DECISION DELEGATED TO HEAD OF PLANNING

Application No: H09-0433-24 **Applicant:** Mr R White
Proposal: Proposed new garage block & altered vehicular access
Location: Farm House Low Road Holbeach Hurn
Terminal Date: 13th August 2024

DRAW N°: MAY RH 01 24
REVISION A REDUCED EAVES HEIGHT JULY 24

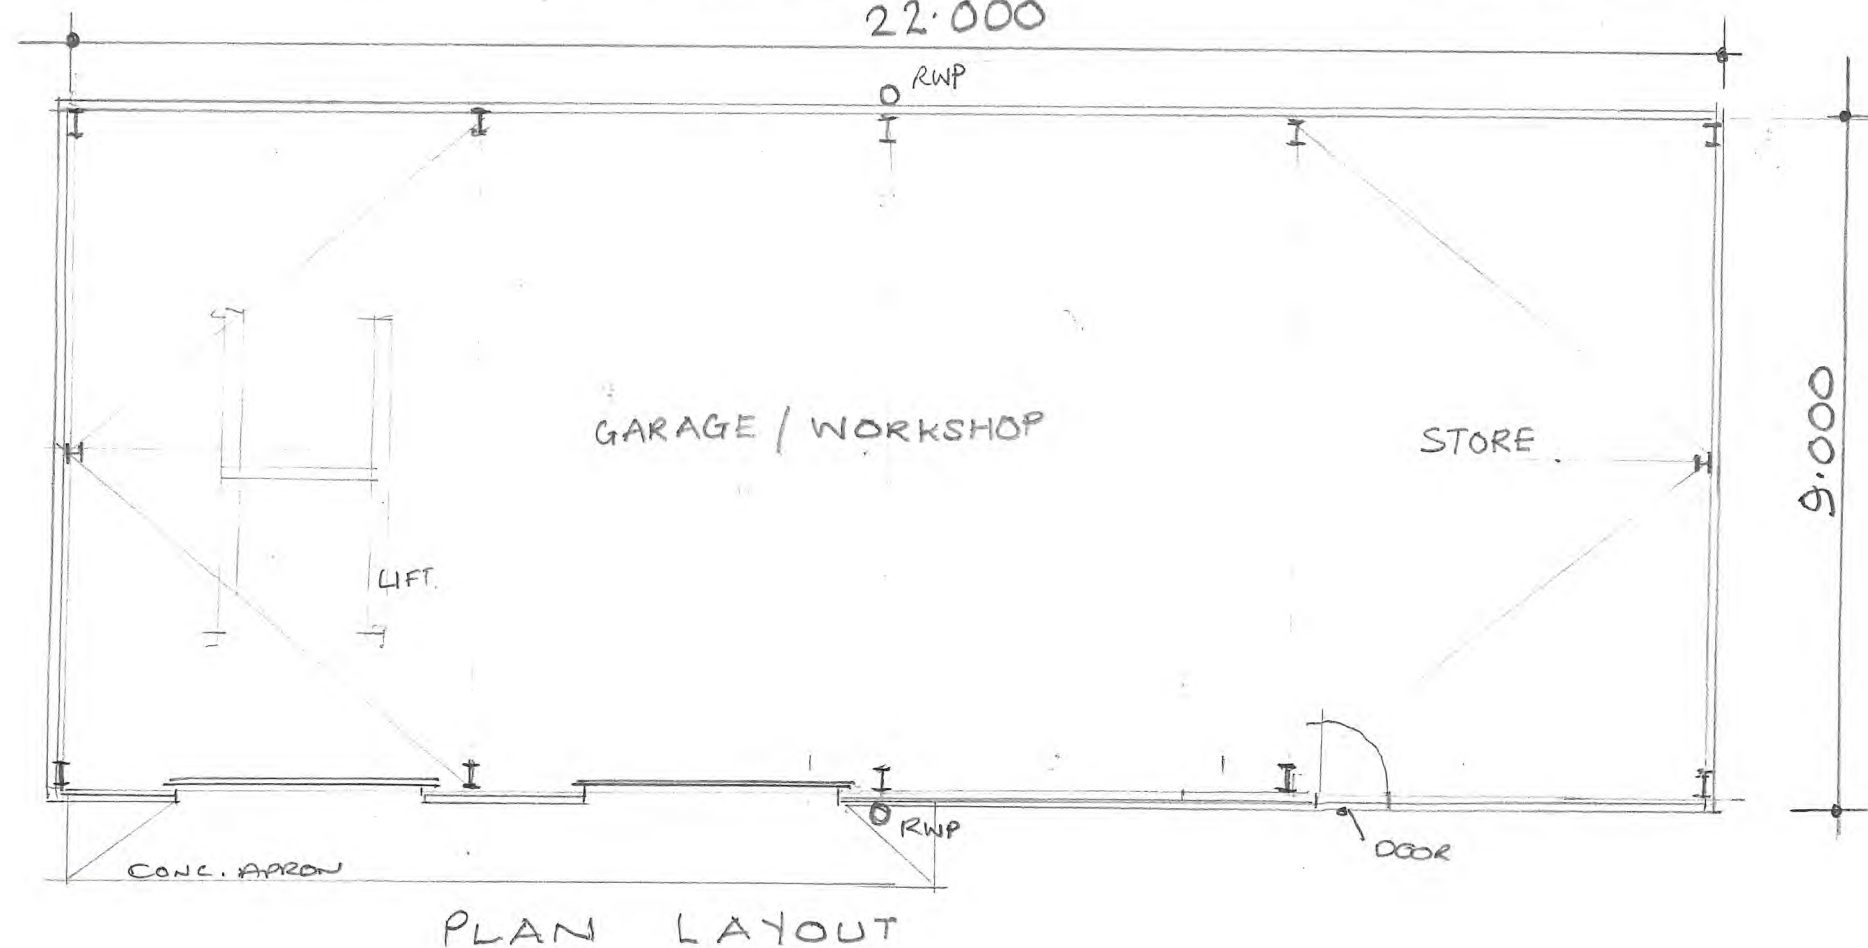
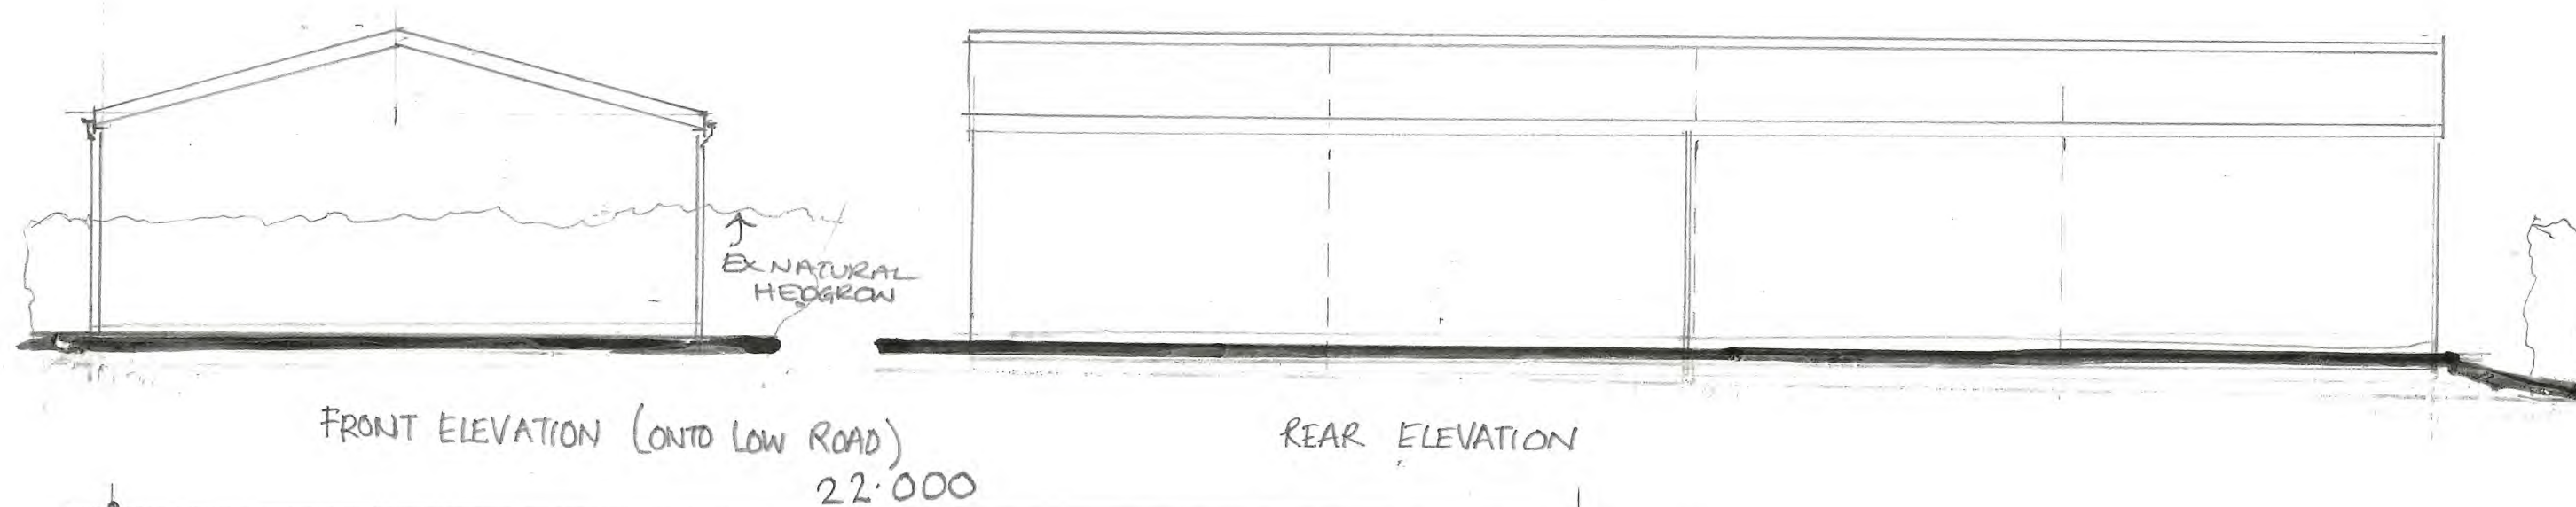
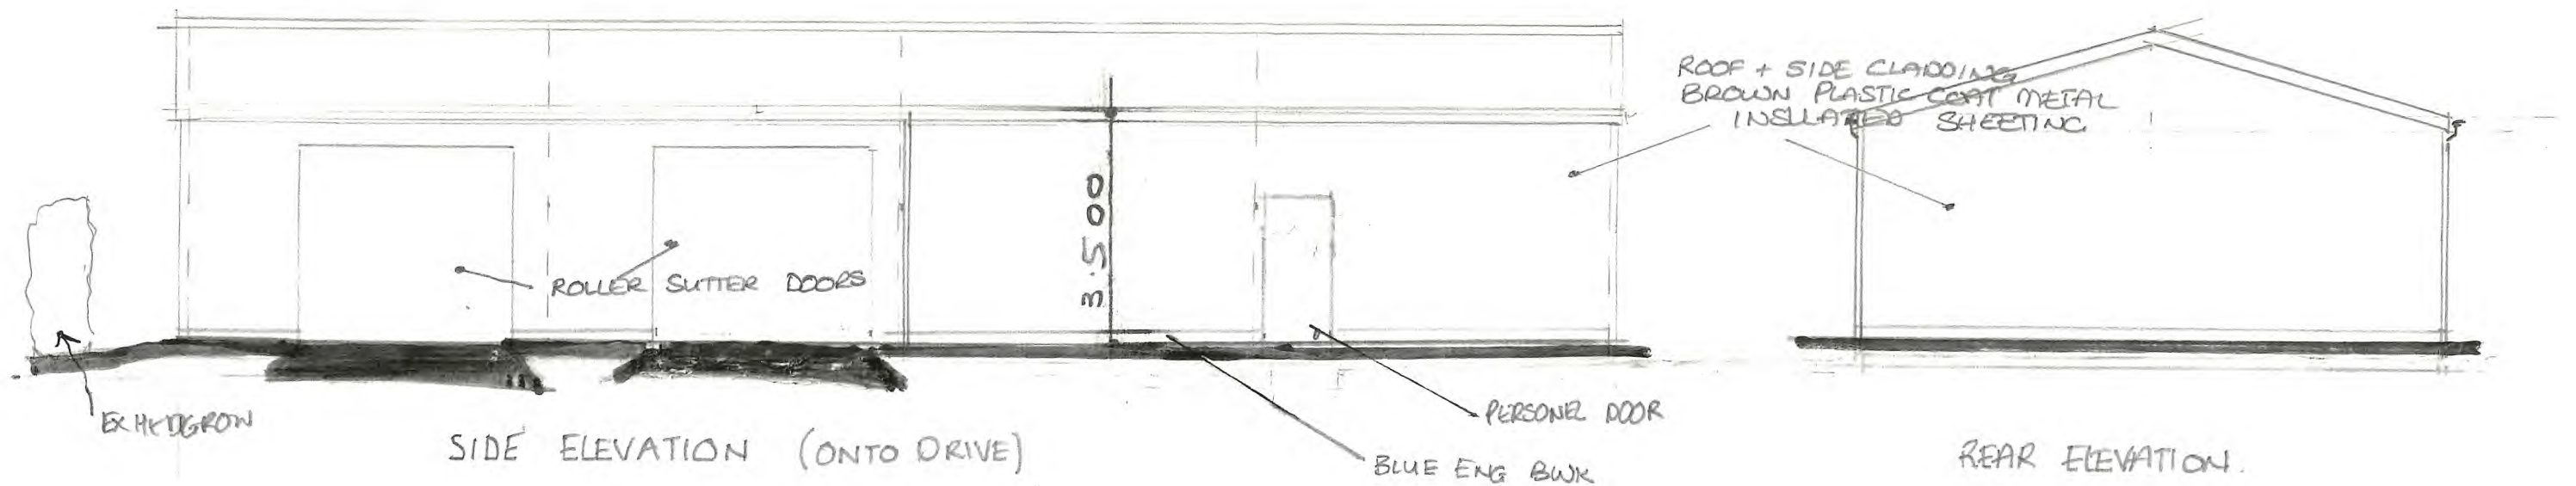
The garage/workshop would have a length of 22 metres, width of 9 metres, eaves height of 3.5 metres and ridge height of 4.9 metres approximately. It would be constructed in plastic coated metal insulated sheeting (brown) with roller shutter doors.

The proposed building has a relatively large footprint and is utilitarian in terms of design and appearance. Moreover, it is forward of the dwelling and would not appear subservient. Taking account of the location, scale and design of the development the proposal is not considered to be acceptable. The proposal would cause an adverse impact to the character and appearance of the rural locality and would not therefore be in accordance with Policies 2 and 3 of the South East Lincolnshire Local Plan and Section 12 of the National Planning Policy Framework (December 2023) and should be refused as a result of this matter.

However, it is considered that the proposed building, by virtue of its location, scale and design/appearance would materially harm the character and appearance of the rural locality. This is contrary to the provisions of the South East Lincolnshire Local Plan, 2019 and National Planning Policy Framework (December 2023) and outweighs other matters in favour of the development.
